WAYNFLETE LOWER SCHOOL - ADDENDUM #3

date: Tuesday, February 14, 2017
project: Waynflete Lower School Addition & Renovations, 2013-0050
prepared by: Austin Smith Scott Simons Architects
to: Cordelia Pitman Wright Ryan Construction
Rick Bergeron Wright Ryan Construction
Luke Dione Wright Ryan Construction
Anne Hagstrom Waynflete School
Patrick Boure Waynflete School
Phil LaClaire PML Project Management

ADDENDUM #3

A1 A-B SWITCHING WITH AUTO OFF VIA CEILING SENSORS

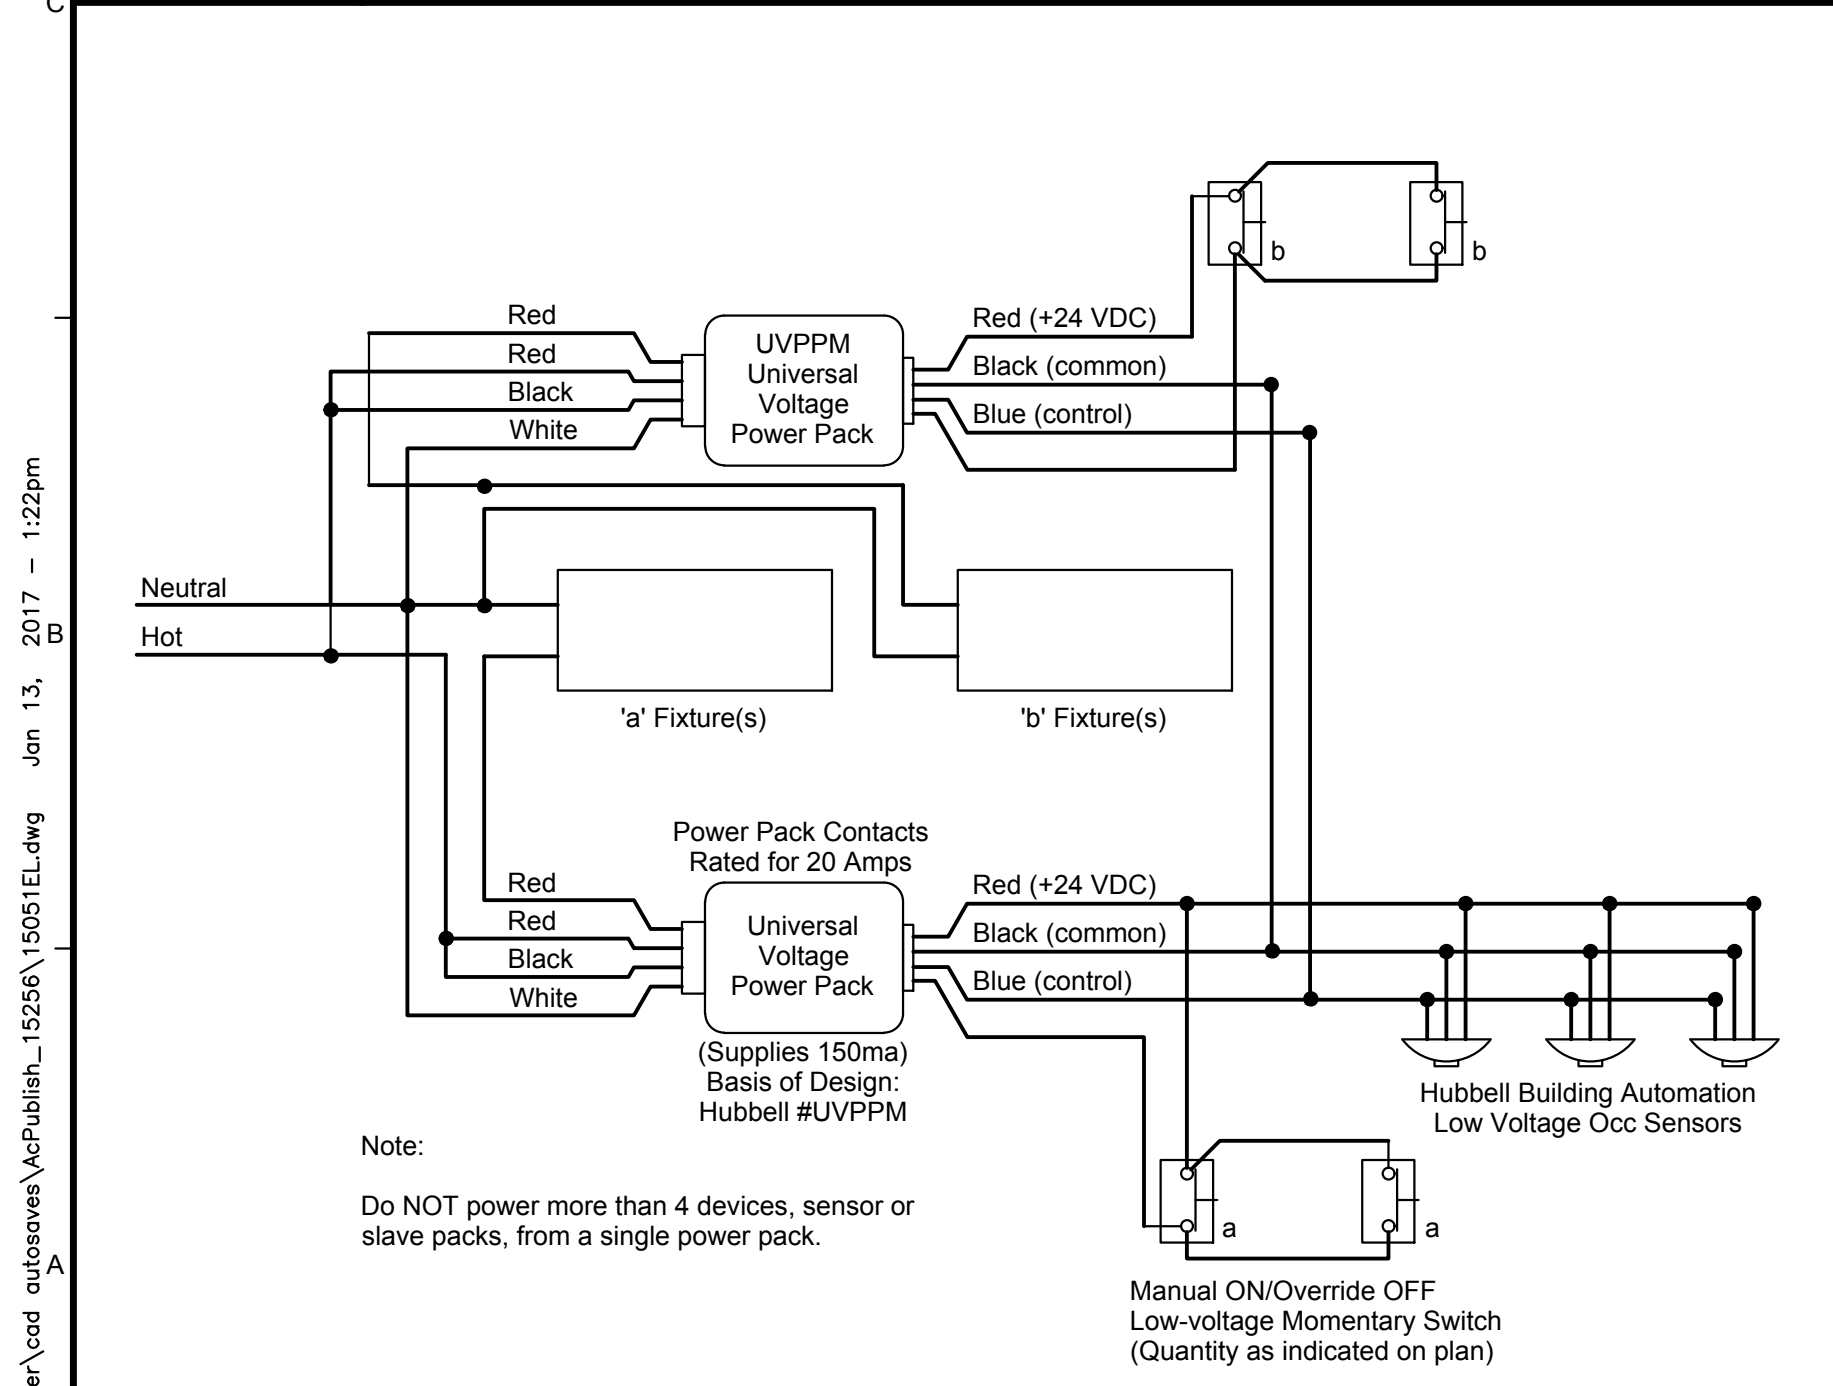
- 3-Q11 Question 11
Q: EL500R: bubbled note 8 refers us to detail A1 on EL600. This detail doesn't exist. Please advise.
A: Bubbled note is #9 and the detail is A1 on EL600R included in Addendum #2.

7 SECTION DETAIL
SCALE: 1-1/2" = 1'-0"

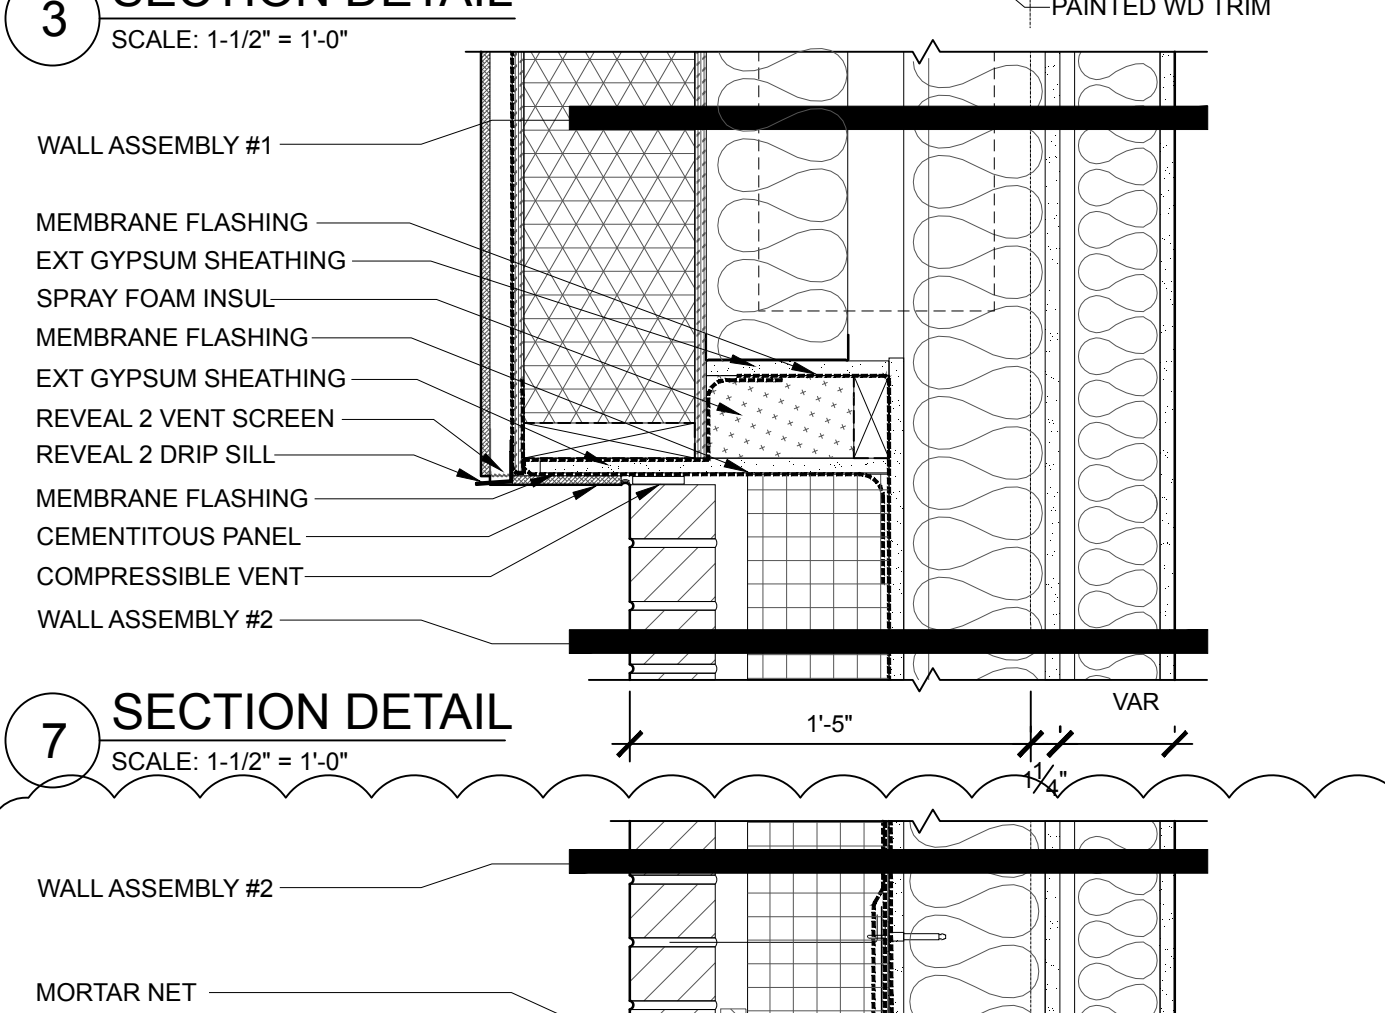
- 3-Q5 Question 5 **Q:** Drawing A141, please clarify what the "1" indicates in "GWB 1" of the Finish Schedule.
A: See note 3-D6 below.
- 3-Q6 Question 6 **Q:** On Drawing A411, detail 7 is listed as Wall Assembly #1. Please clarify the 4 layers of framing with GWB and sheathing.
A: In spaces where wall assemblies transition from one to another, the finished face of wall and associated framing is to be continuous from t.o. slab to b.o. steel above, typ. The framing and sheathing shown beyond what is typical of Wall Assembly #1 is a continuation of Wall Assembly #2 from below. This additional assembly is comprised of the following portion of Wall Assembly #2:
 "EXTERIOR GYPSUM SHEATHING

- 3-Q7 Question 7 **Q:** On Drawing A411, What will the bottom of the wall behind the SIP panel be fastened to?
A: Specific to Detail 7, see Section Detail 1 on S3.3. Provide splice connection between CFMF as part of delegated design framing package.

- 3-Q8 Question 8
Q: On Drawing A411, detail 7 indicates at the offset lists multiple trades for the blocking, sheathing, flashing, spray foam insulation etc. please clarify how that will be coordinated and who is responsible for what.
A: Please defer to WRC on questions of means and methods.

- 6" METAL FRAMING
 - CELLULOSE INSULATION (6"-R-21) (To overlap 4'-0" min. with SIP panel assembly.)
 - GWB – TAPED AND MUDDDED
 - METAL FRAMING
 - 5/8" PAINTED GWB"
 Please refer to Wall Section 2/A311 for further context. Please also refer to partition types keyed in plans for locations where interior walls are furred out in addition to the exterior wall assembly.

**A511R**

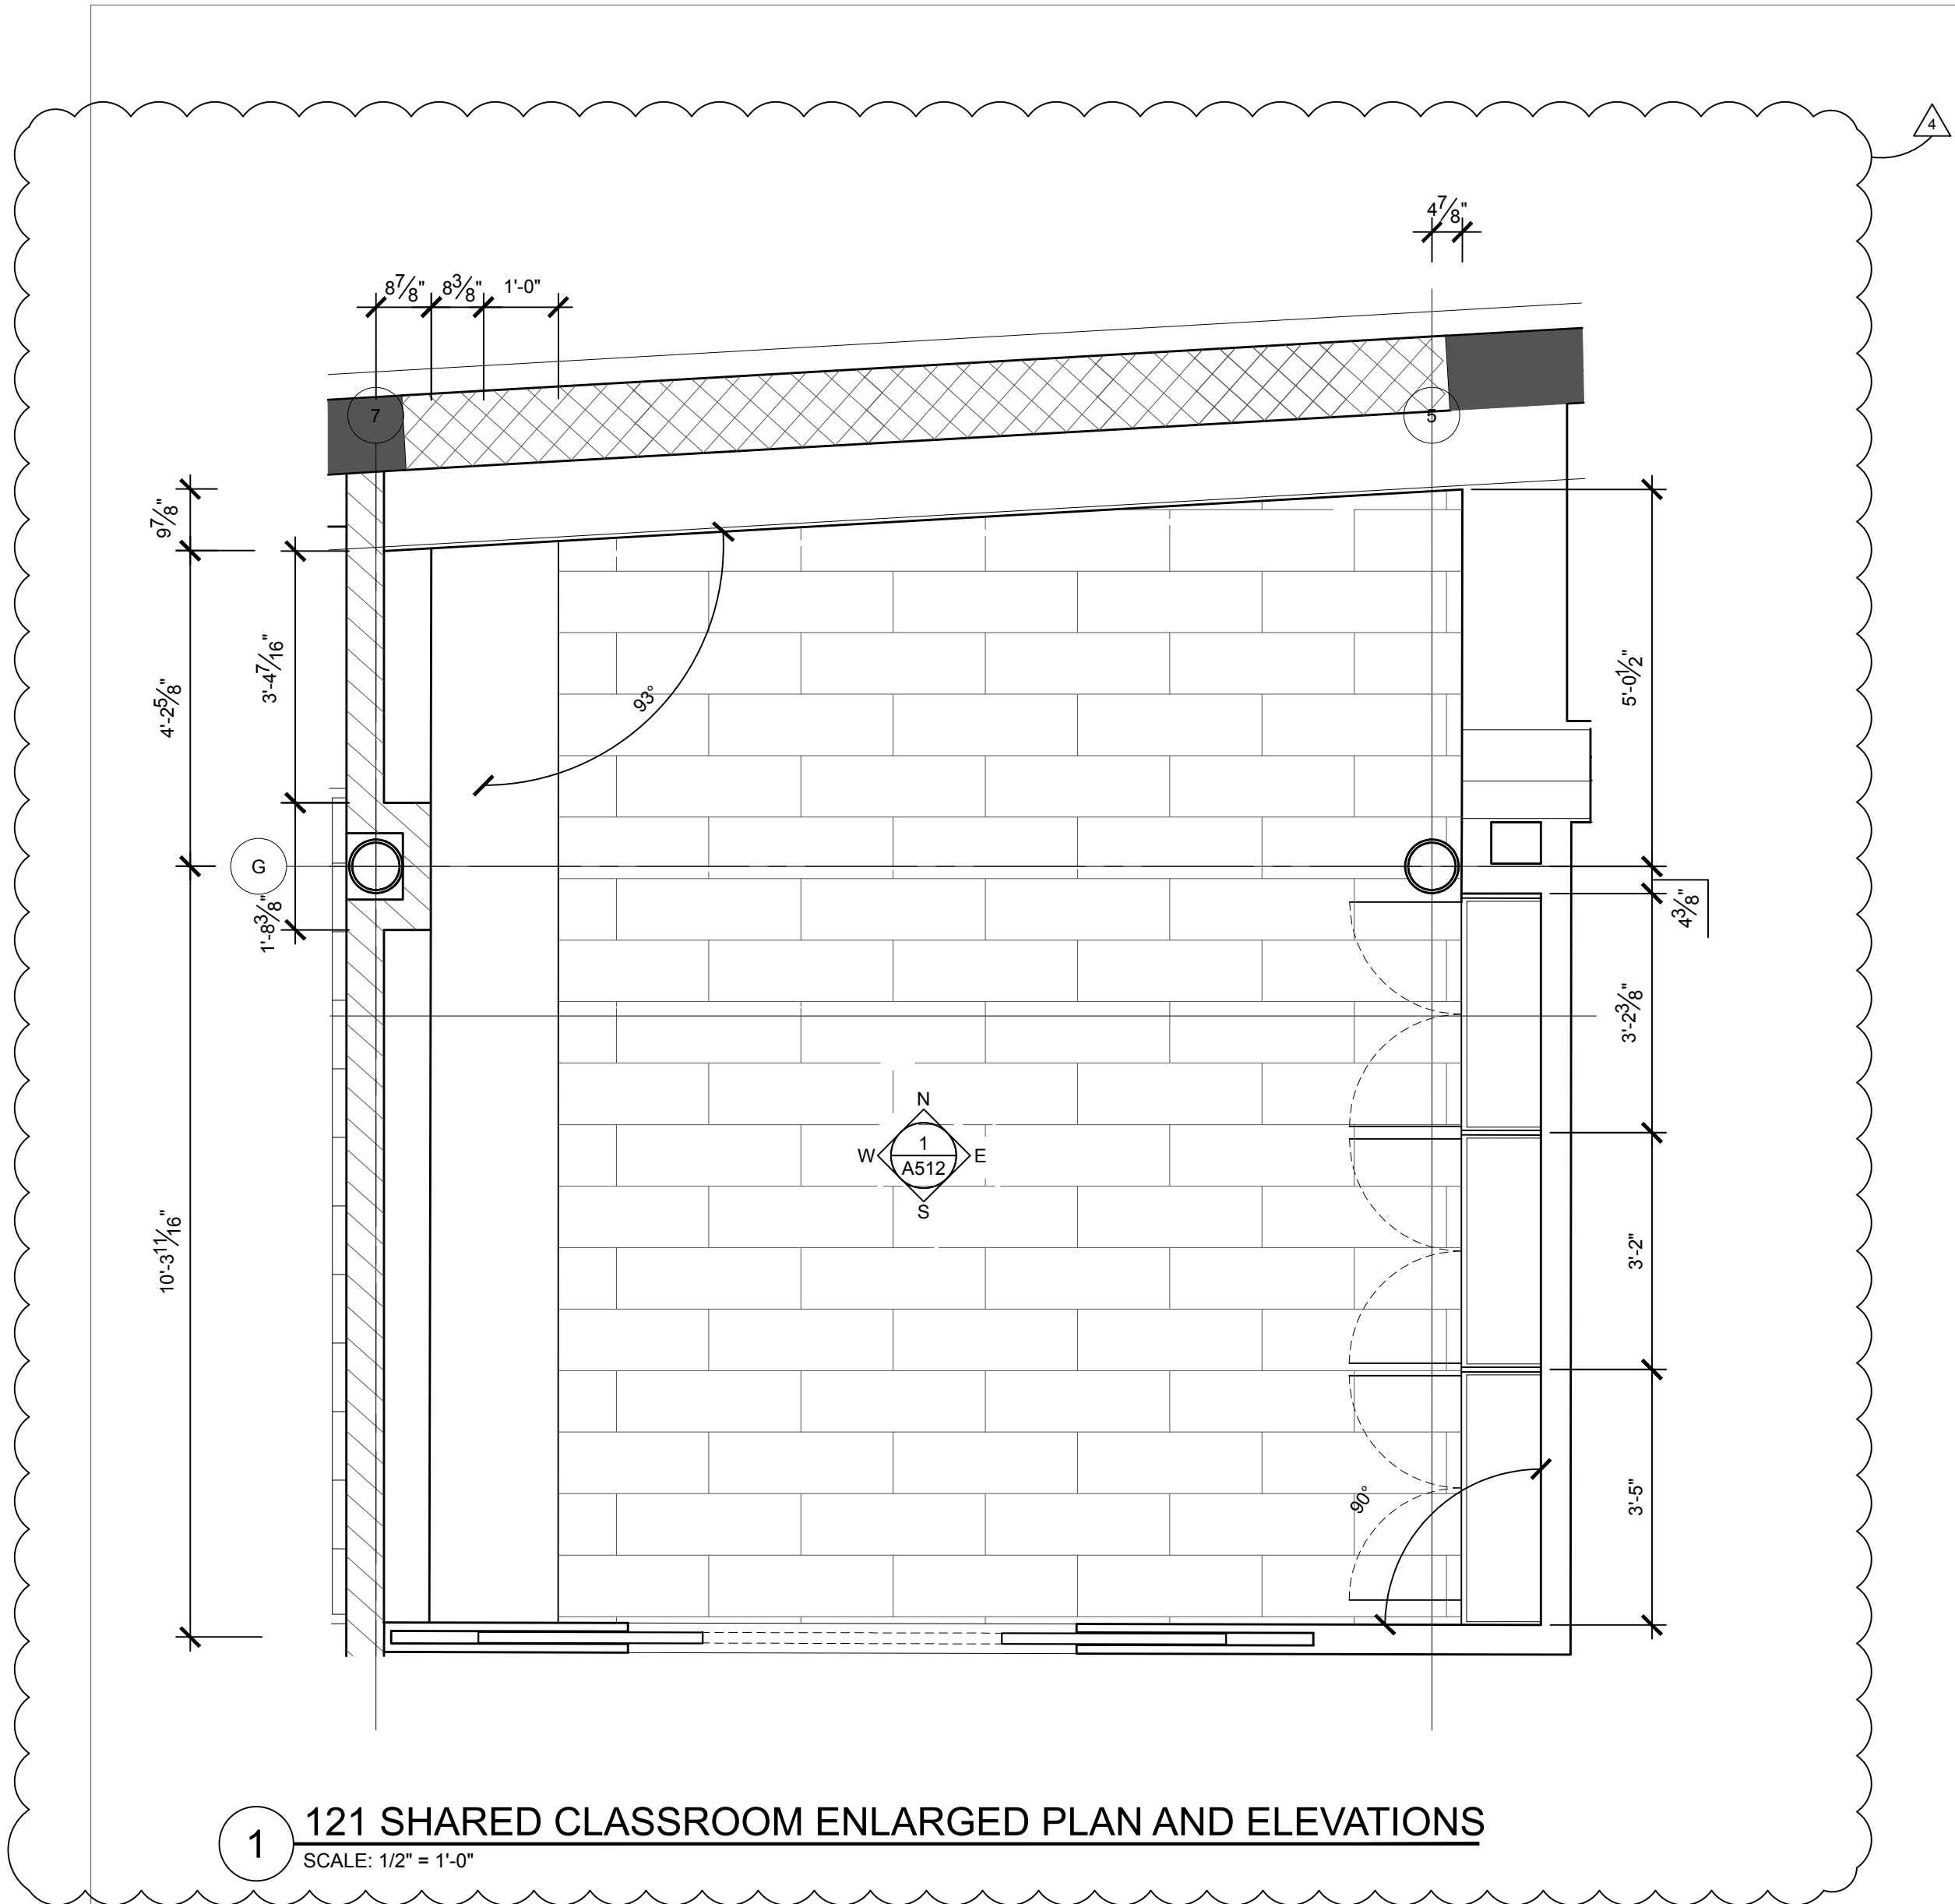
- 3-Q10 Question 10
Q: Spec. on A-511 does not match mirror in specs. which is correct? Mirror part number in specs. does not match mirror verbiage in specs. which is correct?
A: See 3-S6 and 3-D7 below.

- 3-D7 Sheet A511 At Bathroom Accessories Schedule:
Delete: “M1 / MIRROR / ASI / 0535 / 24” W x 36” H”
Add: “M1 / MIRROR / BOBRICK / B-165 / 24” W x 36” H”
